Planning Application No: 3/2023/0756

Proposed single-storey extensions to rear, replacement porch to front, alterations to fenestration. Demolition of existing garage and replacement with new garden room and new garden office.

Location: 15 Billington Gardens Billington BB7 9LU

PROPOSED SITE PLAN - SCALE 1:200

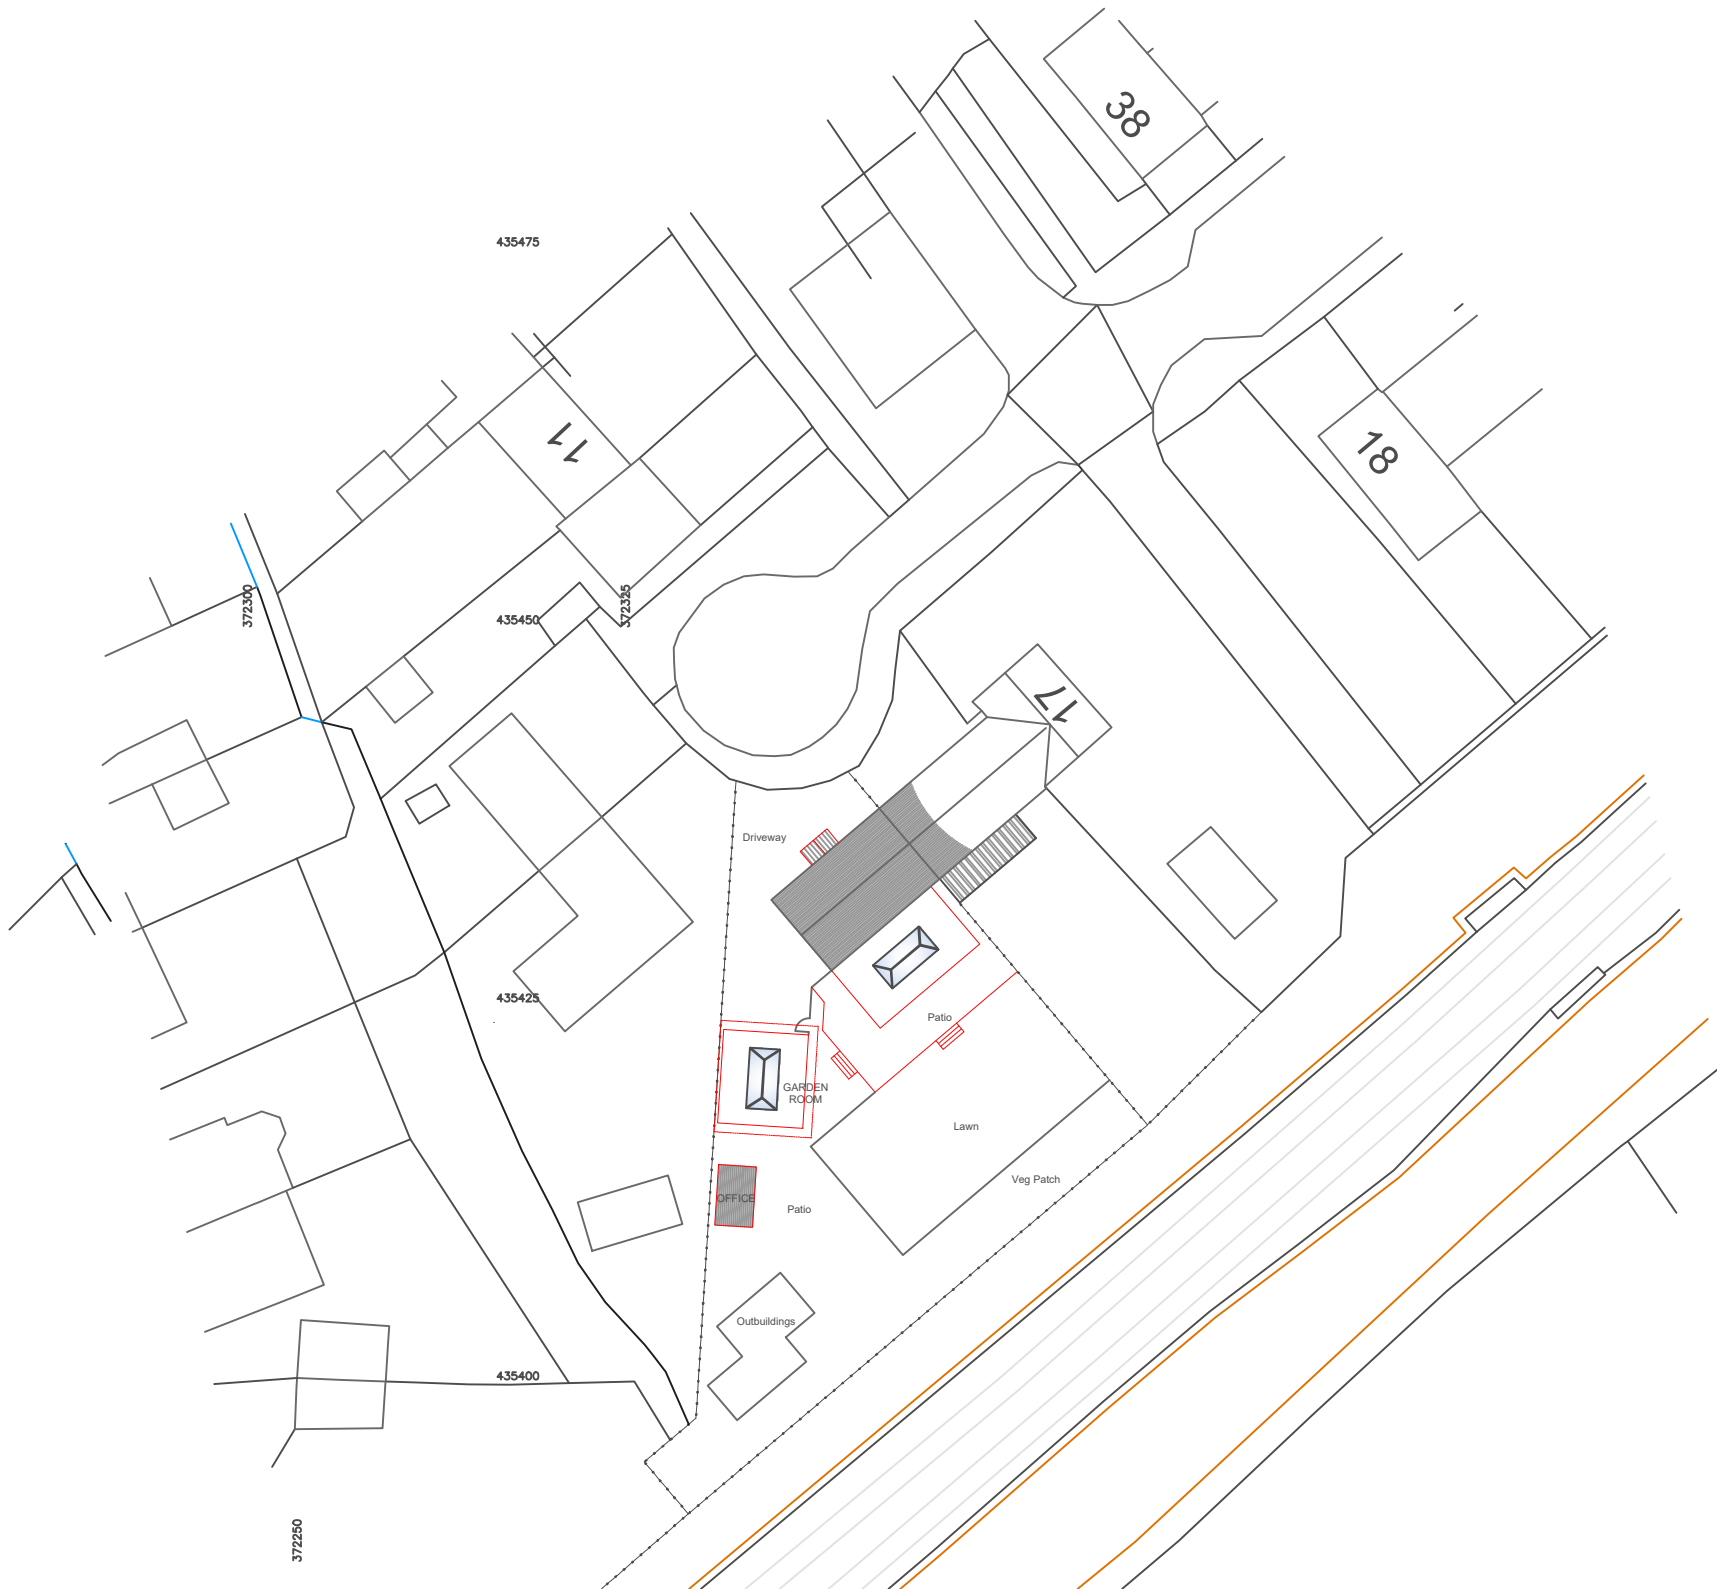
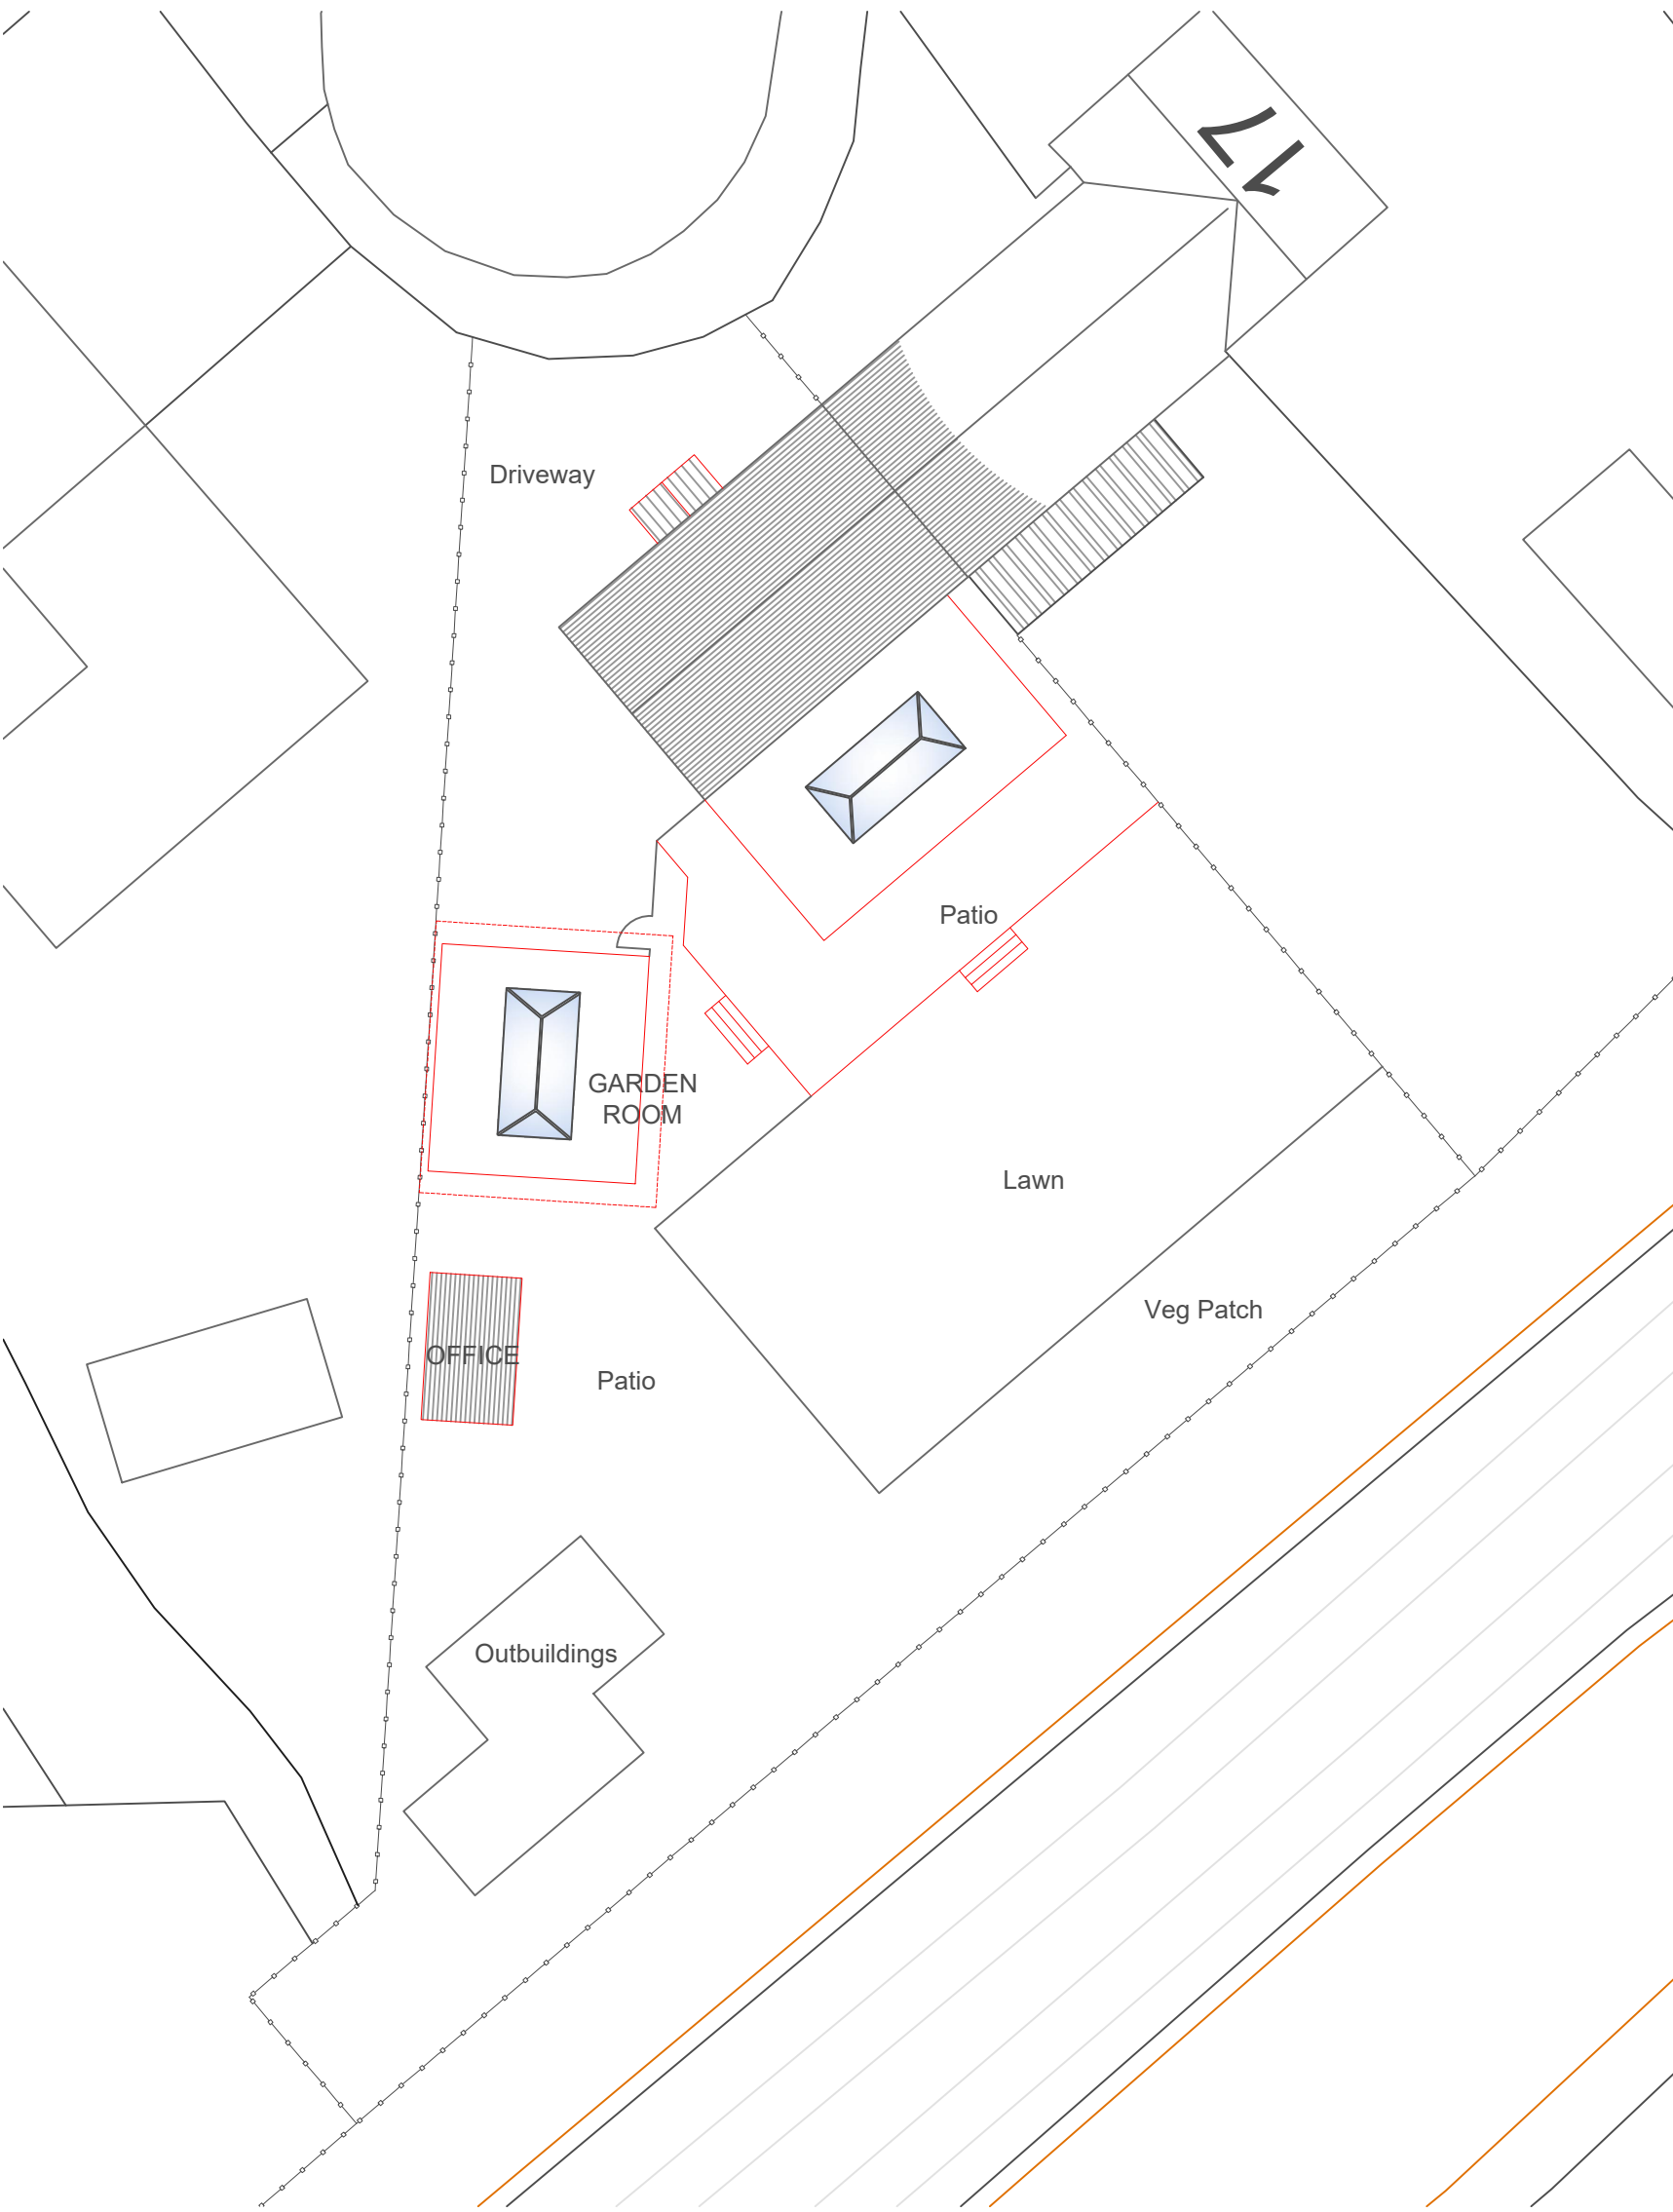
There is a loss of an existing garage with this proposal, however 2 parking spaces remain for this 3 bedroom property, therefore, parking standard requirement are being met. Parking on a turning circle is not acceptable for highway safety reasons.
